# CITY OF ALBUQUERQUE

December 4, 2018

RE: **Lomas Carwash Expansion**  
**9935 Lomas NE**  
**Grading Plan Stamp Date: 11/30/18**  
**Drainage Report Stamp Date: 12/1/18**  
**Drainage File: J20D003**

Based on the submittal received on 12/3/18, the grading plan and drainage report cannot be approved until the following are corrected:

GRADING AND
DRAINAGE PLAN

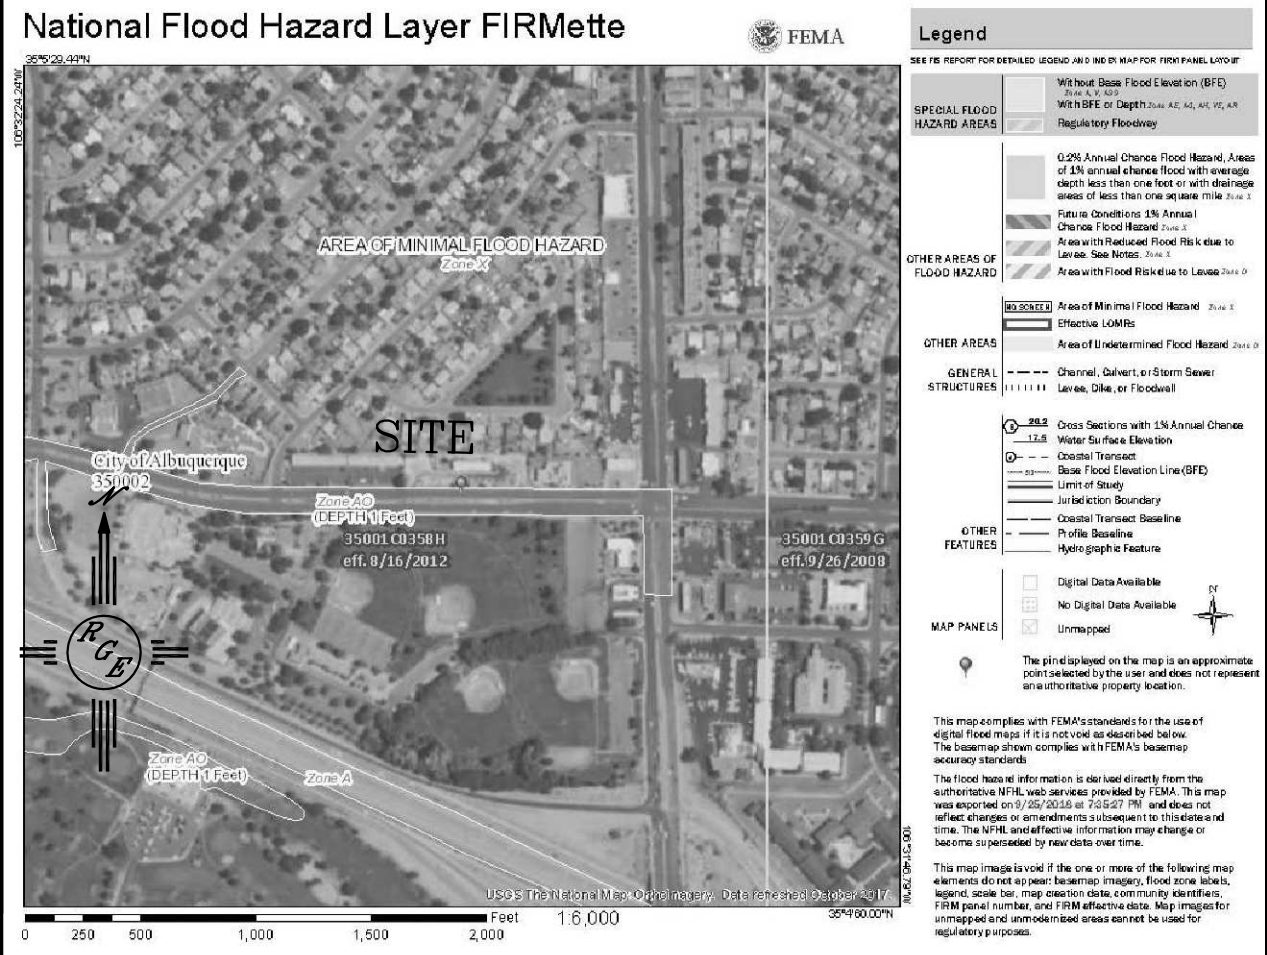
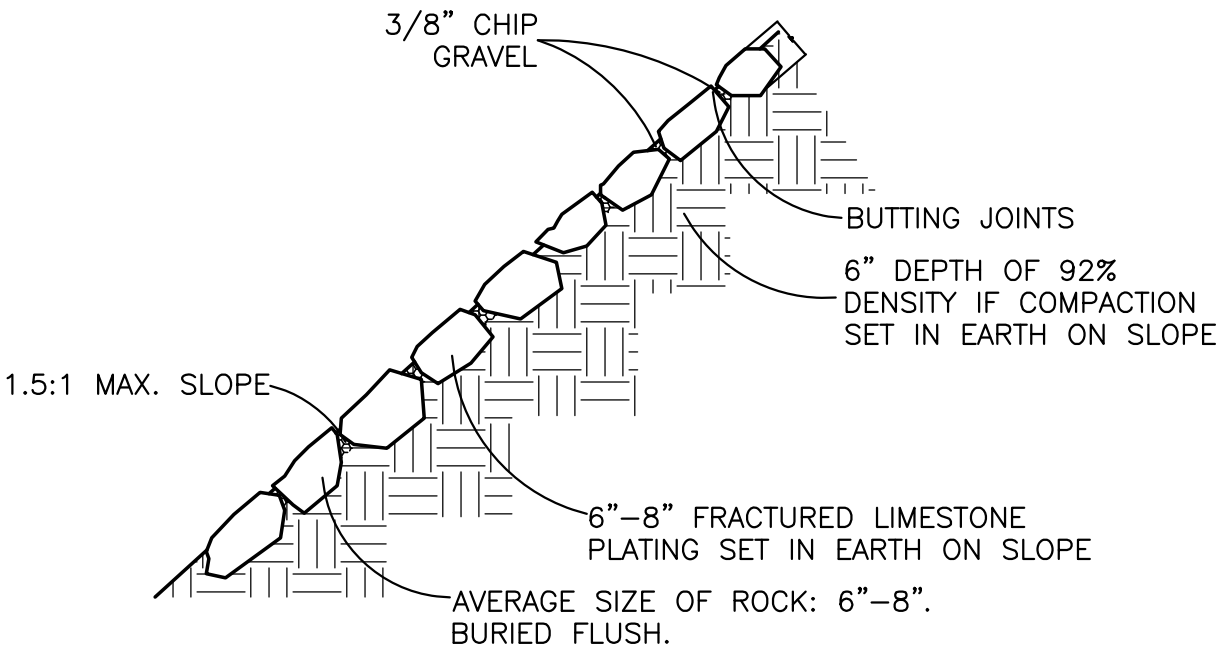
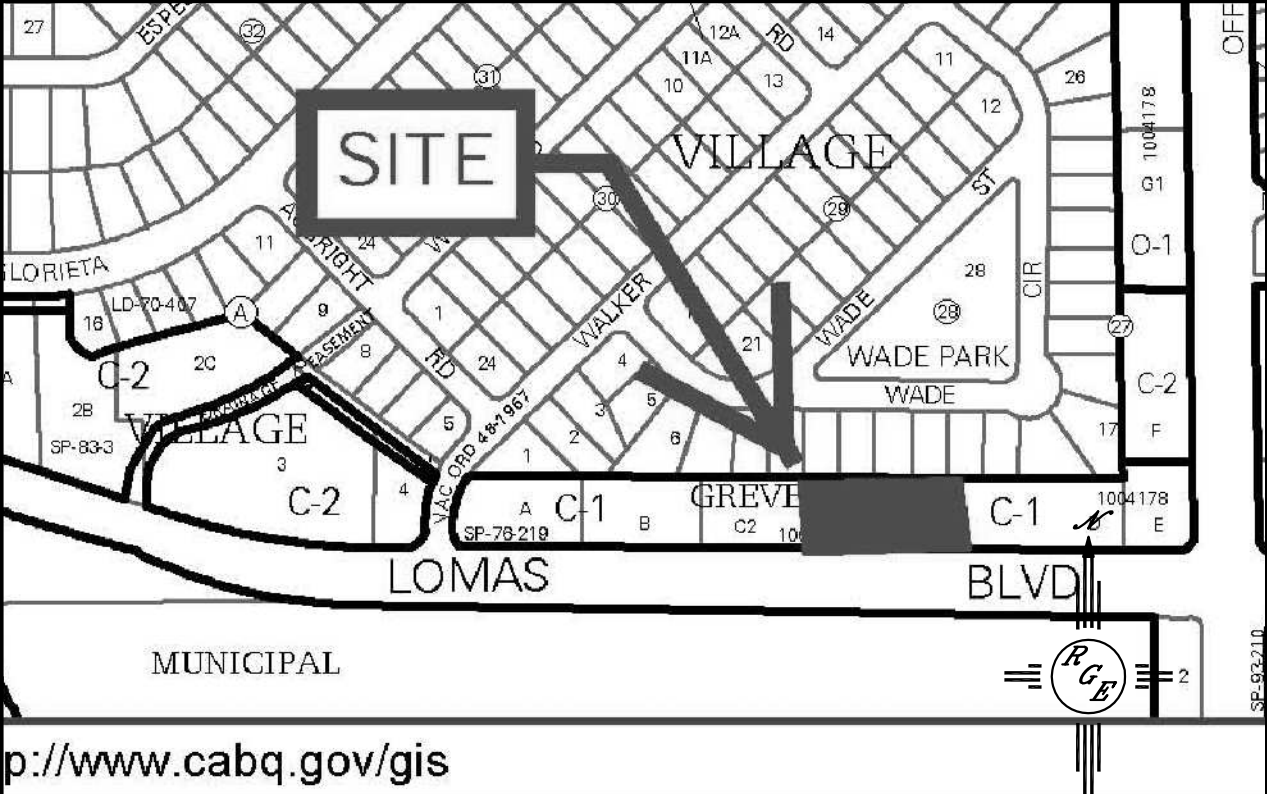
1. A digital (.pdf) submittal, emailed to PLNDRS@cabq.gov is required.
2. Provide 1' (minimum) freeboard on the main pond. Provide a section through the berm and specify 95% compaction and a compacted structural key-in. Include an armored emergency spillway, sized for the 100-yr peak inflow. A short retaining wall may be needed along the west face of the berm in order to meet freeboard and catch grade.
3. If requesting Payment-in-Lieu of treating the stormwater quality volume (SWQV), use the attached treasury deposit slip to pay the amount (\$232) requested and include a copy of the paid receipt with your resubmittal. Otherwise provide Management Onsite or request a Waiver of Management Onsite per § 14-5-2-6 (H).
4. If requesting a Waiver of Management Onsite, the following conditions of the new drainage ordinance (enacted 10/2/18) must be demonstrated on the plan (§ 14-5-2-6 (H)):

Show where stormwater quality can be effectively controlled through private offsite mitigation, or through an arrangement to utilize a cooperator's existing regional stormwater management infrastructure or facilities that are available to control stormwater quality.
